## **Thorpe on the Hill Parish Council (PC) IP Ref: [REDACTED]**

### **Mitigation of the proposed FGE Solar Farm on the “Stepping Out” (SO) routes in Thorpe on the Hill**

Indicative Single Axis Tracker Site Layout Plan

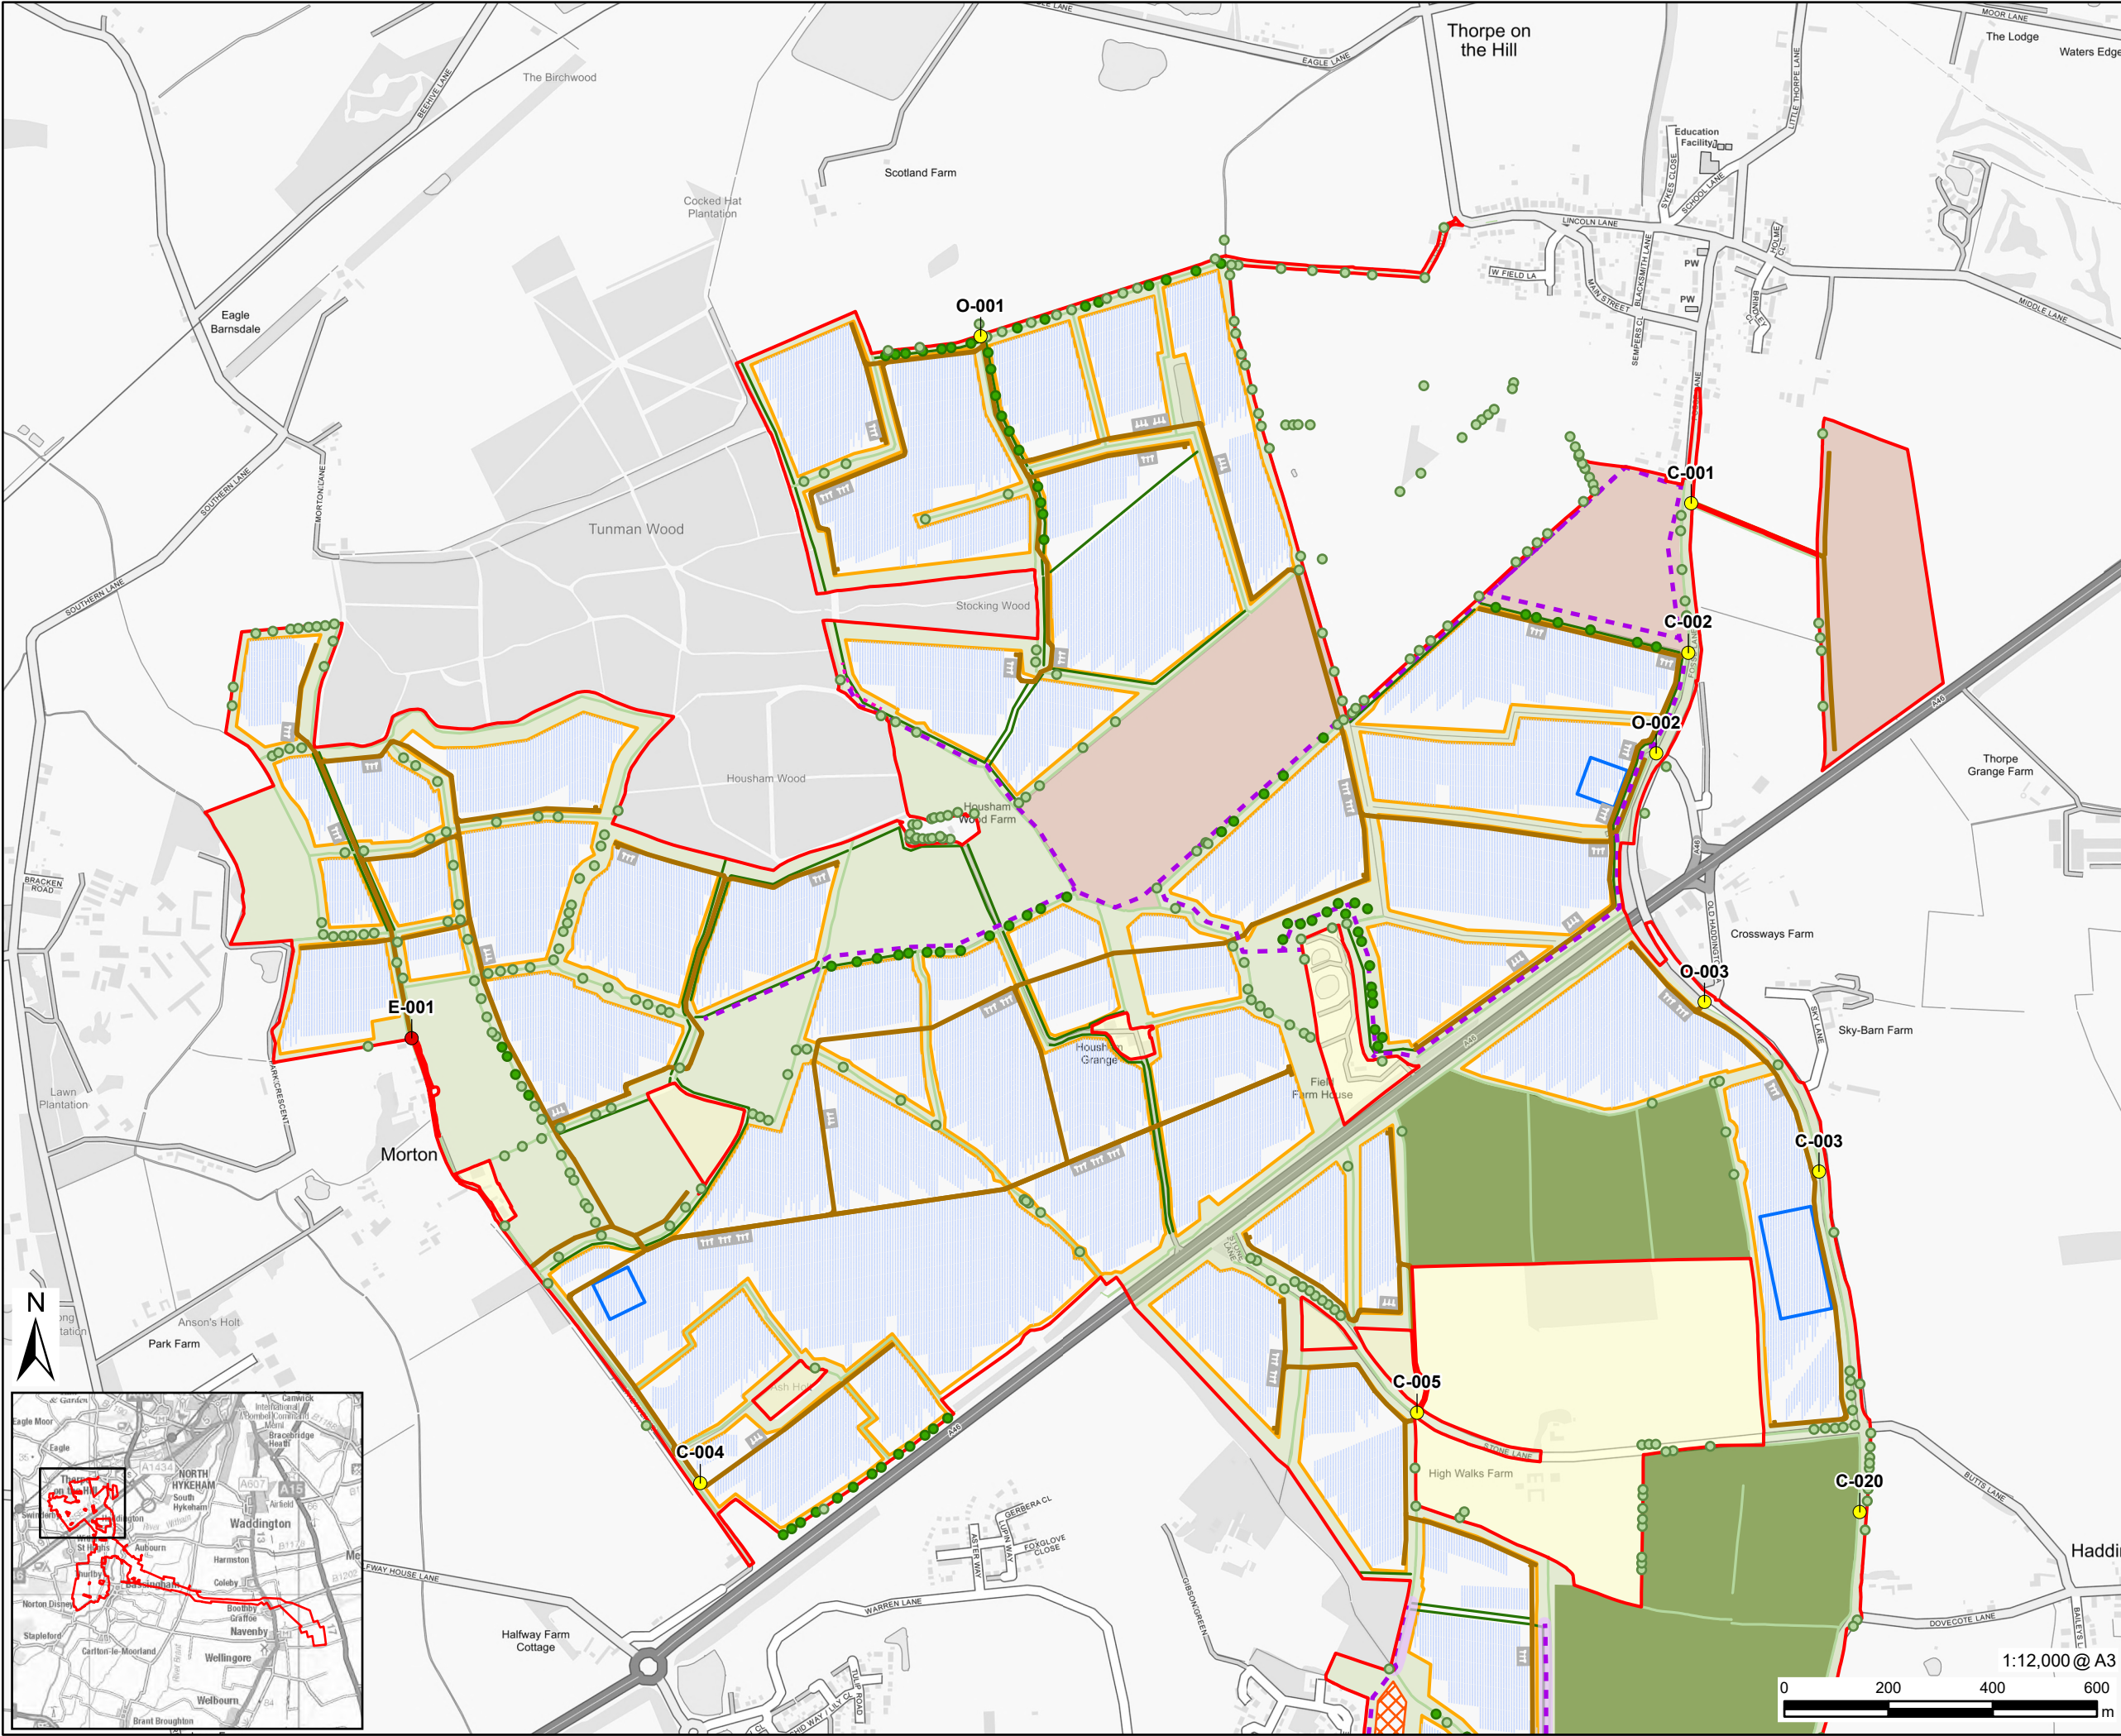
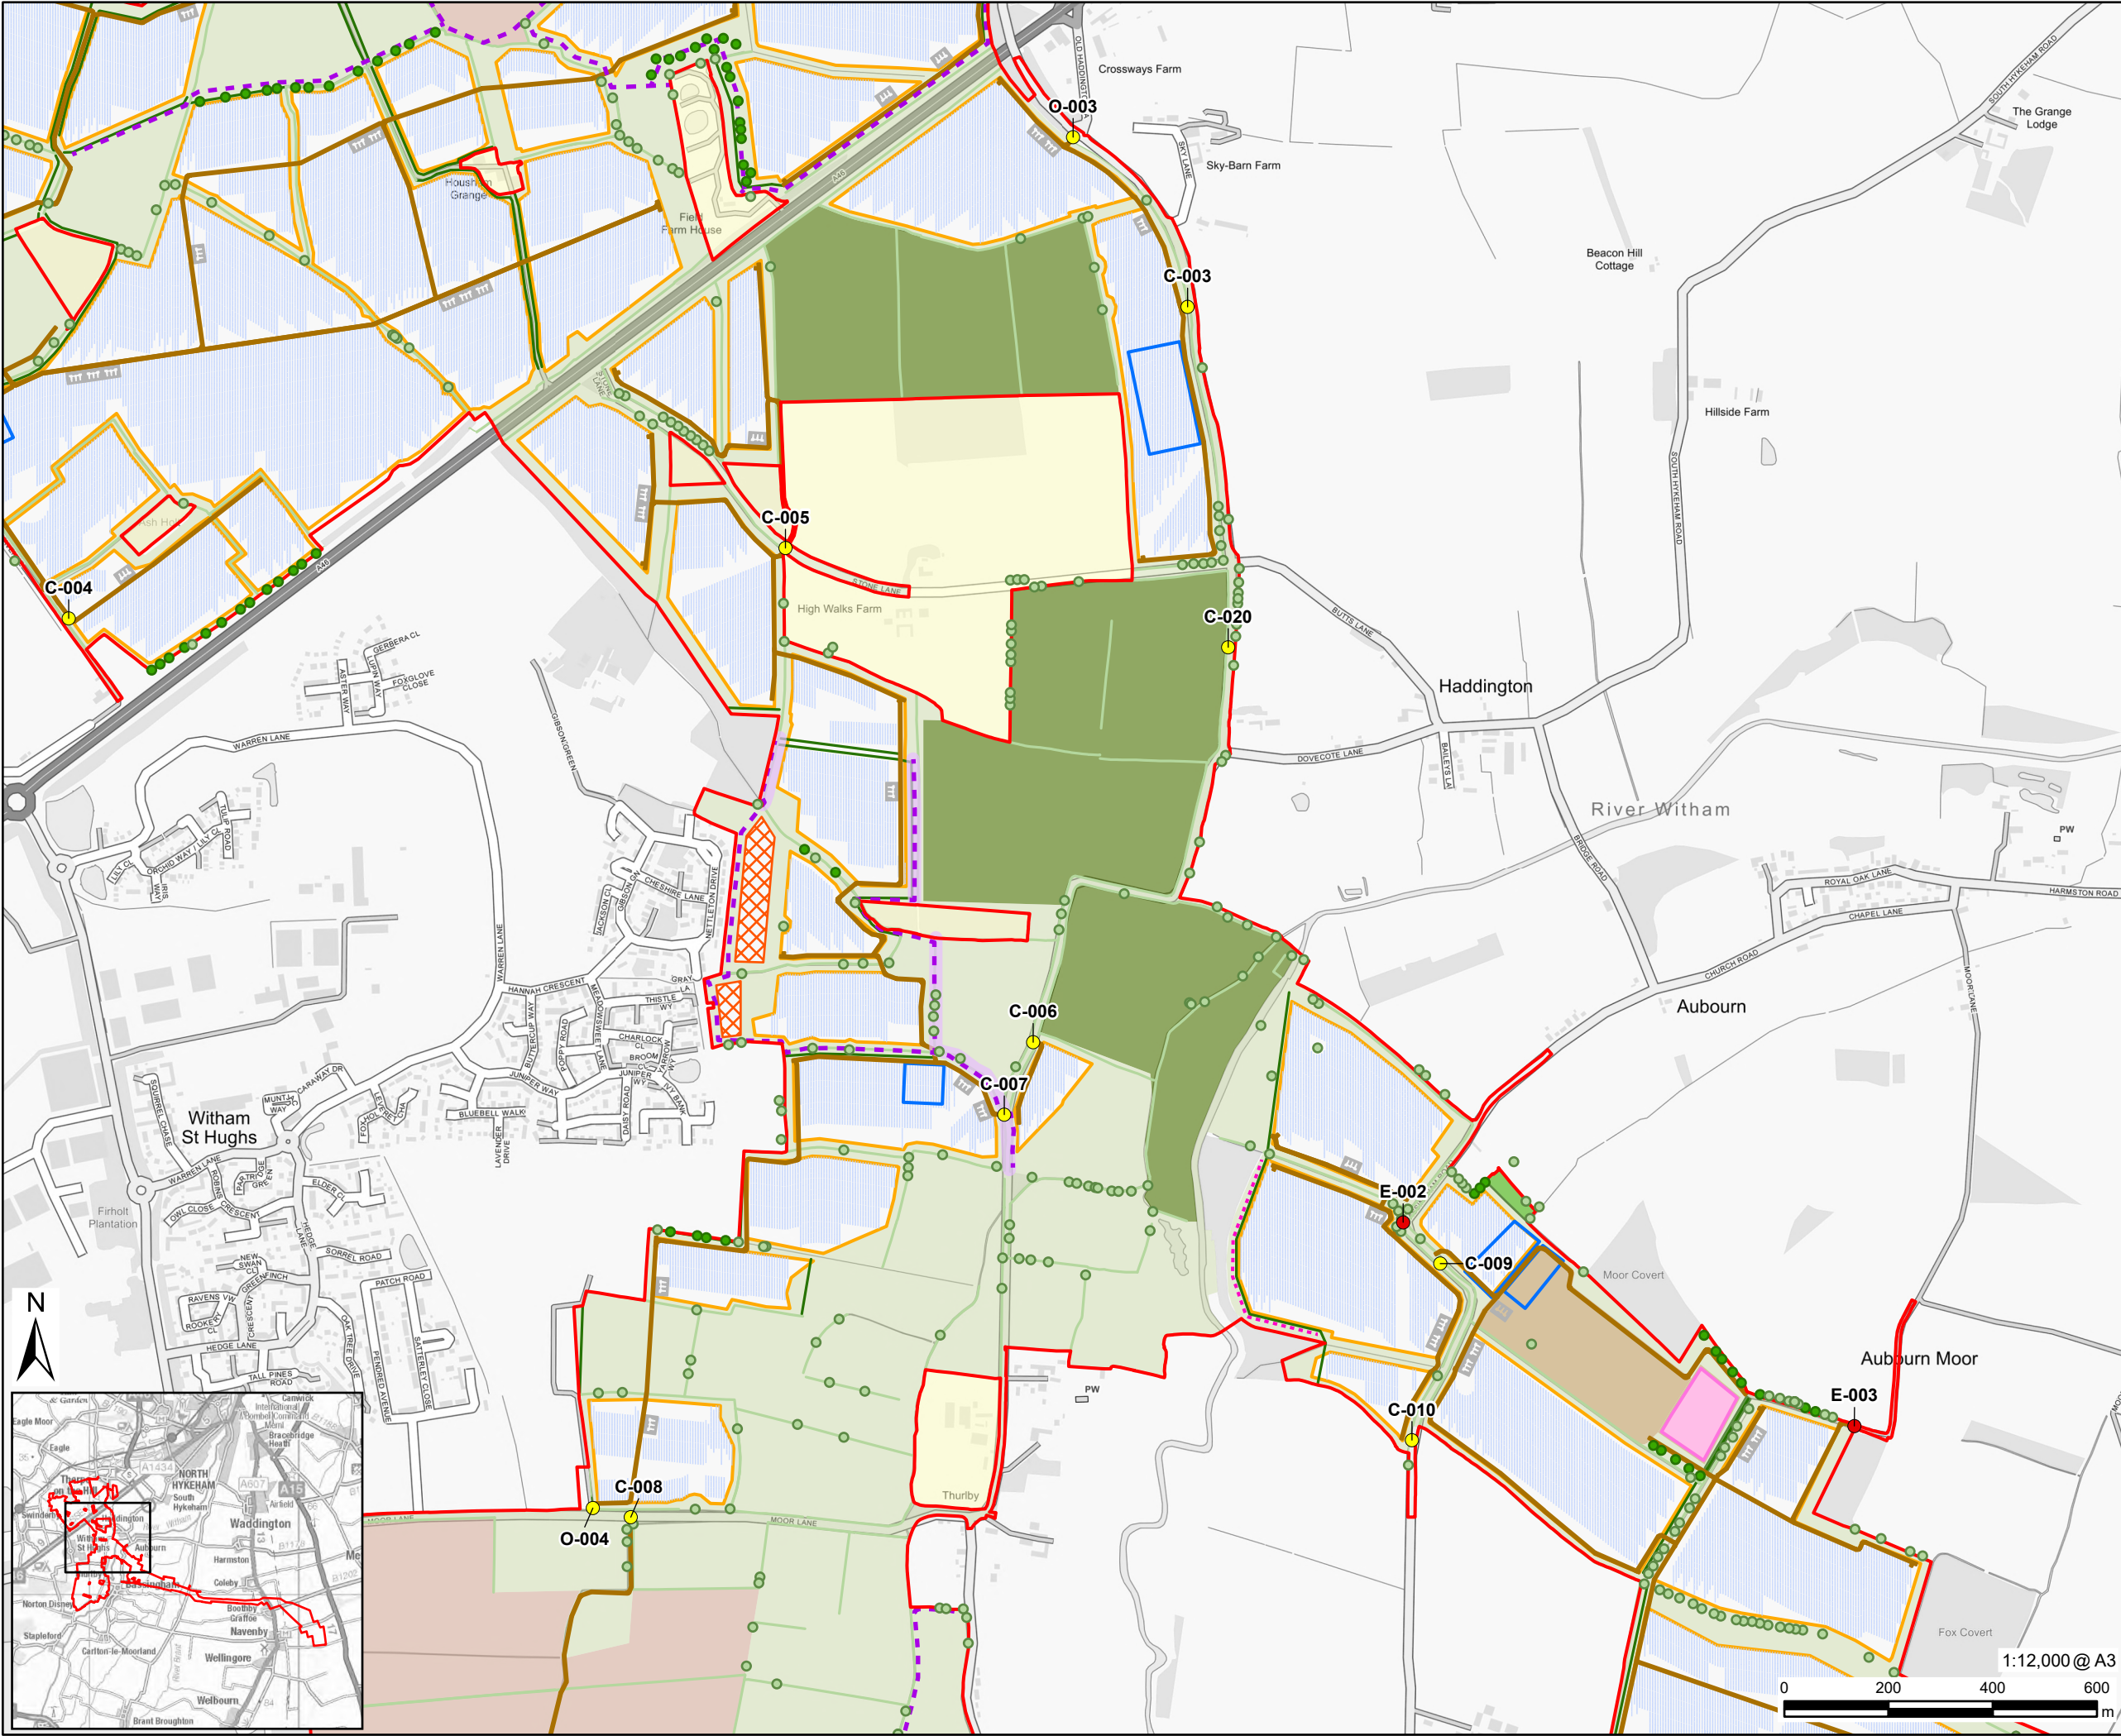
The PC does not believe that adequate consideration has been given to properly mitigating the potential effects of the proposed scheme on these routes. The following pages of this document contains reminders of the routes themselves which have been copied from the promotional leaflets. The diagram on page 4 is taken directly from the applicant’s documents FGE 2.2 Works Plans APP-008 EN010154 and shows the layout of solar arrays in the area surrounding the SO routes.

- Avoid any corridors where the SO routes would pass through solar arrays on both sides of the path creating tunnel effects. As a compromise solar arrays on one side of paths, where views are less important, are included
- Try to retain key views to Tunman Wood from the village and from Tunman Wood back to the village
- Try to retain key views identified in Thorpe on the Hill’s Neighbourhood plan
- Maintain, so far as is possible, open views which are characteristic of the locality rather than restrictive hedgerows which block key views
- Avoid changes which impact the integrity of the applicant’s proposal by requiring different access points or new parcels of land

Thorpe PC cannot claim professional planning expertise however, these simple revisions which are shown on page 5 appear very practical and do not require wholesale design changes to the applicant’s proposals. They would result in a reduction in area of solar arrays in the affected areas close to the SO routes but it might possible to recoup these elsewhere. If implemented, the PC believes they would enable many of the key features and benefits of the SO routes to be retained.
